**Flintshire County Council's response to**

**Table 2-2 Applicant's Comments on Submissions Received at Deadline 3 from Flintshire County Council [REP3-047] and also**

**Table 2-3 - Flintshire County Council's response to the to the Applicant's comments to Flintshire County Council's Final Local Impact Report (25 April 2023) [REP1A-005] and [REP3-046] and subsequent responses at Deadline 3**

**Submitted at Deadline 5 – Tuesday 4 July 2023**

Work No. 38

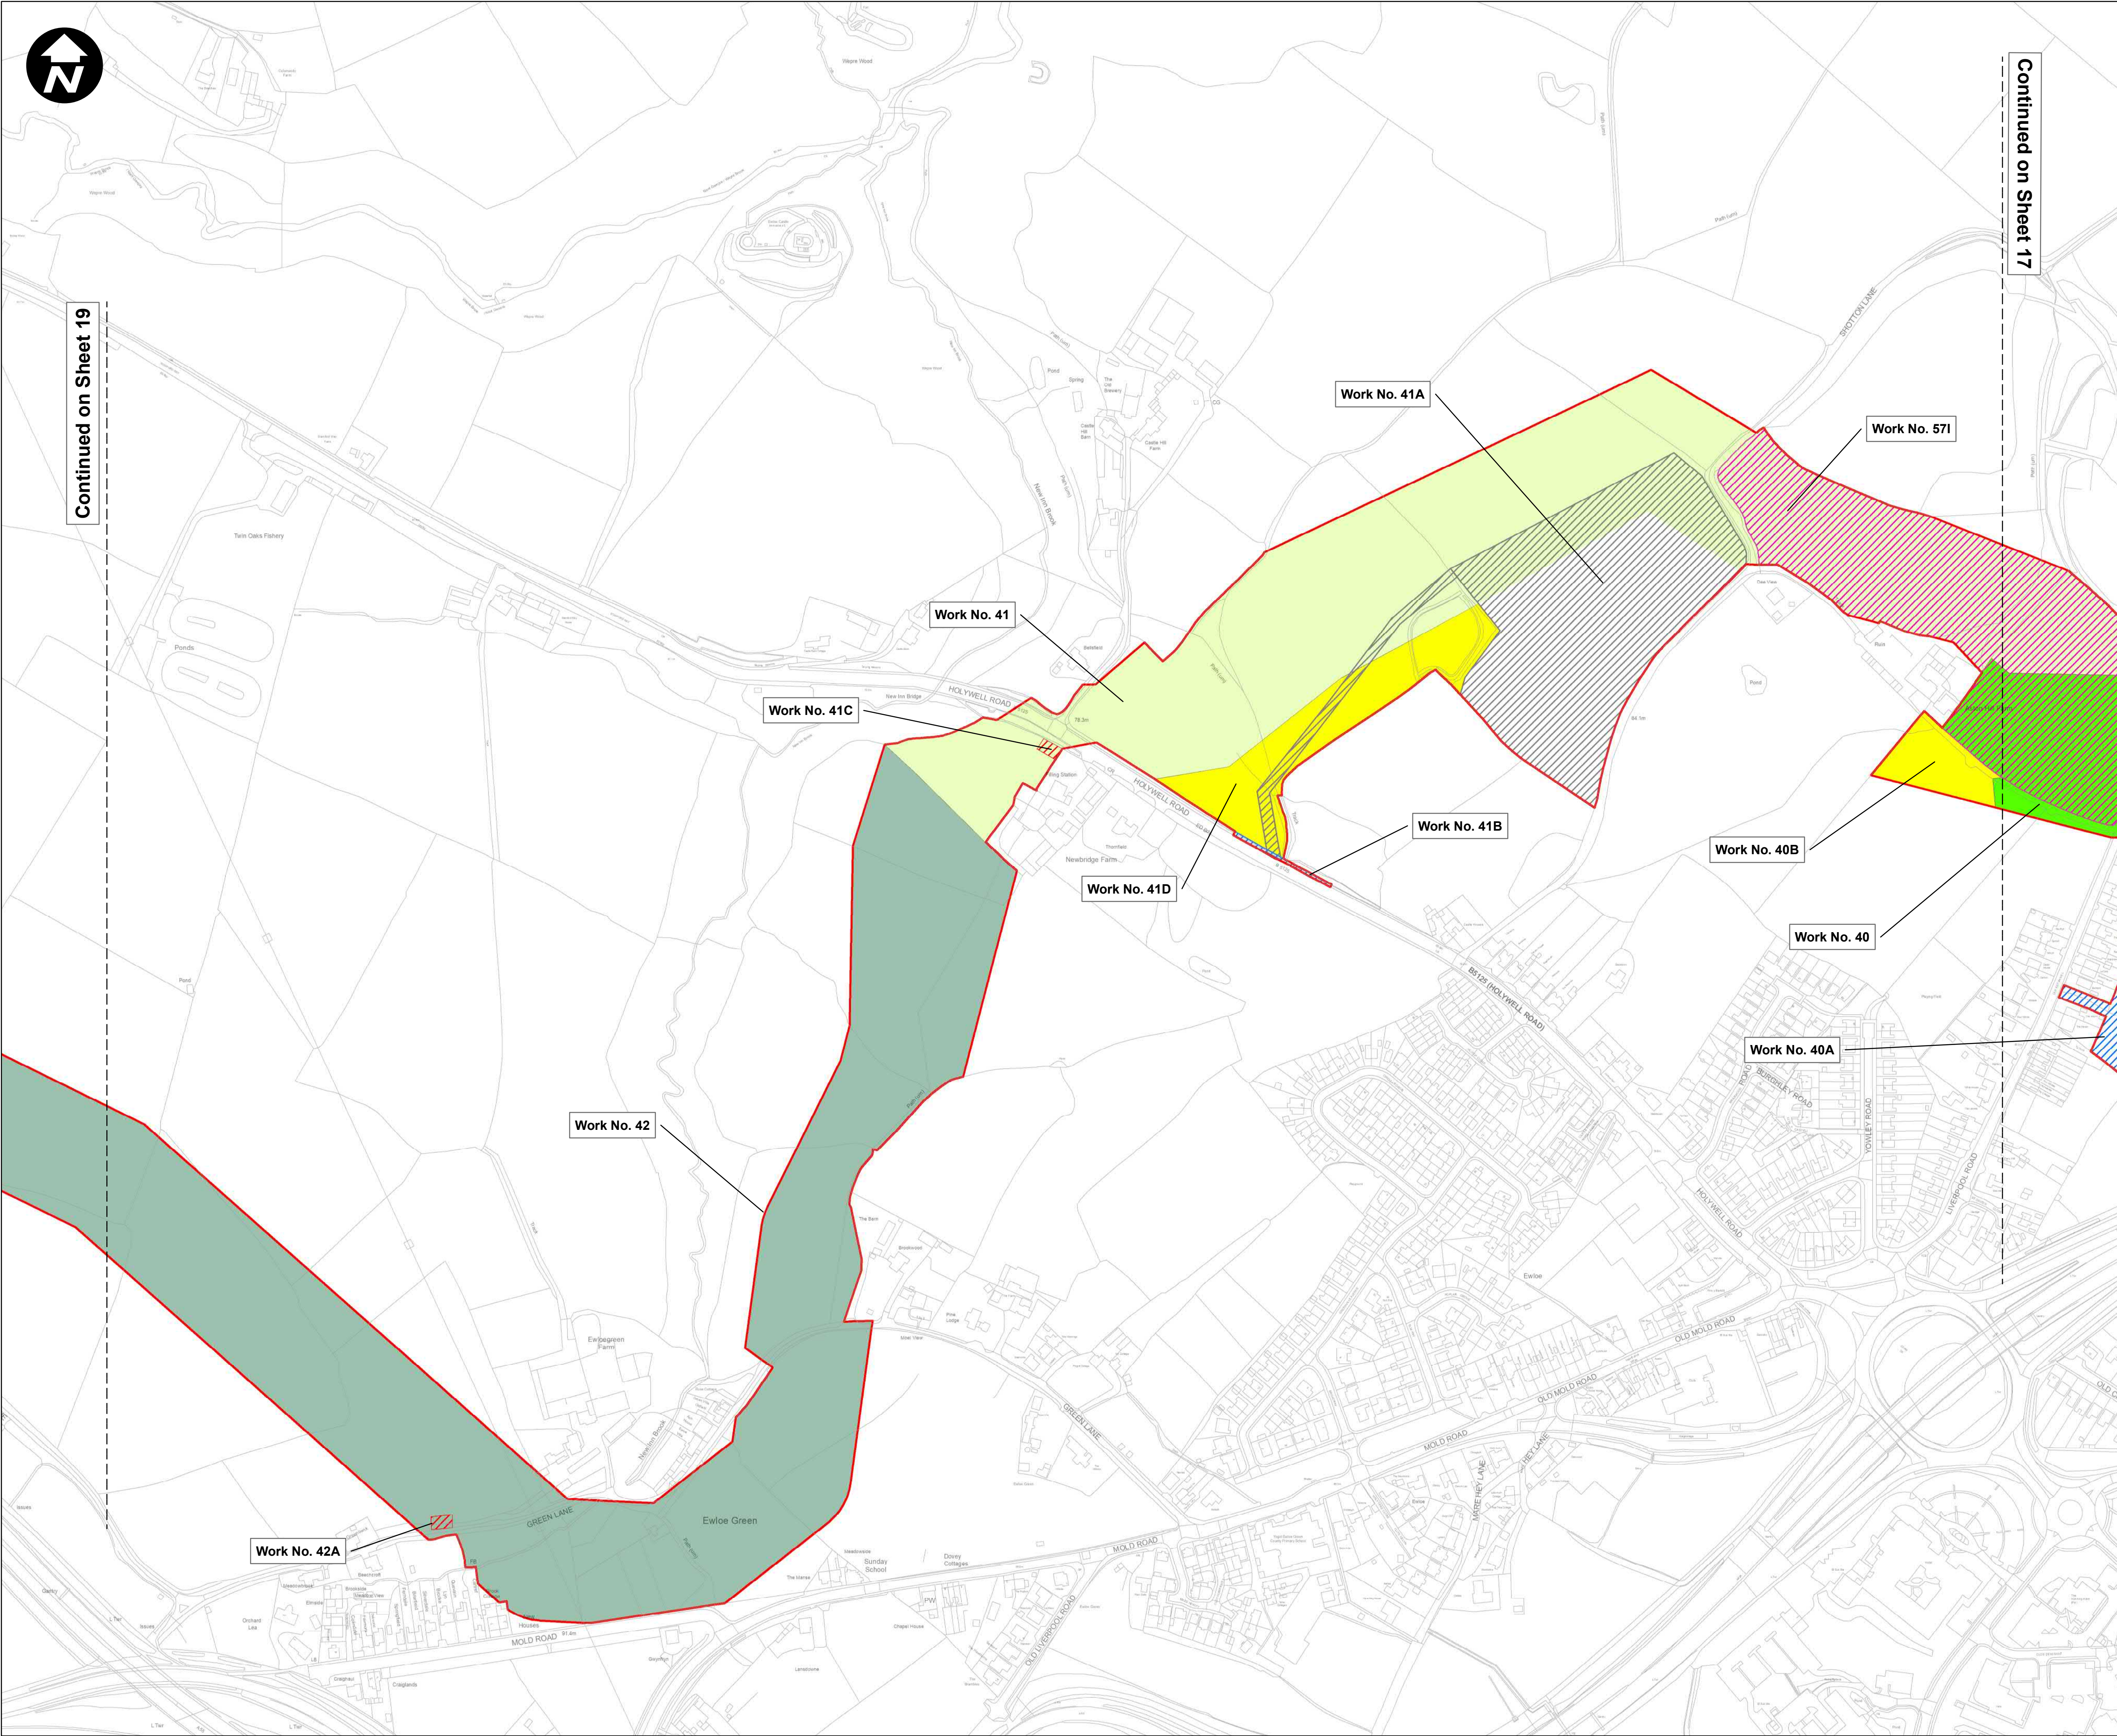
Work No. 38B	Creation and use of a temporary construction access from Lower Aston Hall Lane, within the location shown on Sheet 17 of the Work Plans, including— (a)	This would appear to cross PROW 303/26/10. The route would need to be adequately incorporated into any new access. In the DCO this is described as a	The Applicant notes the access at Work No. 38B is permanent. The Applicant has updated the text of Work No. 38B in Schedule 1 of the draft DCO to state “permanent” from Rev B [REP1-004].	The Council welcomes the clarification regarding the wording.  Noted	The Applicant welcomes FCC's confirmation that they are satisfied with this point.	Noted, FCC have no further comments
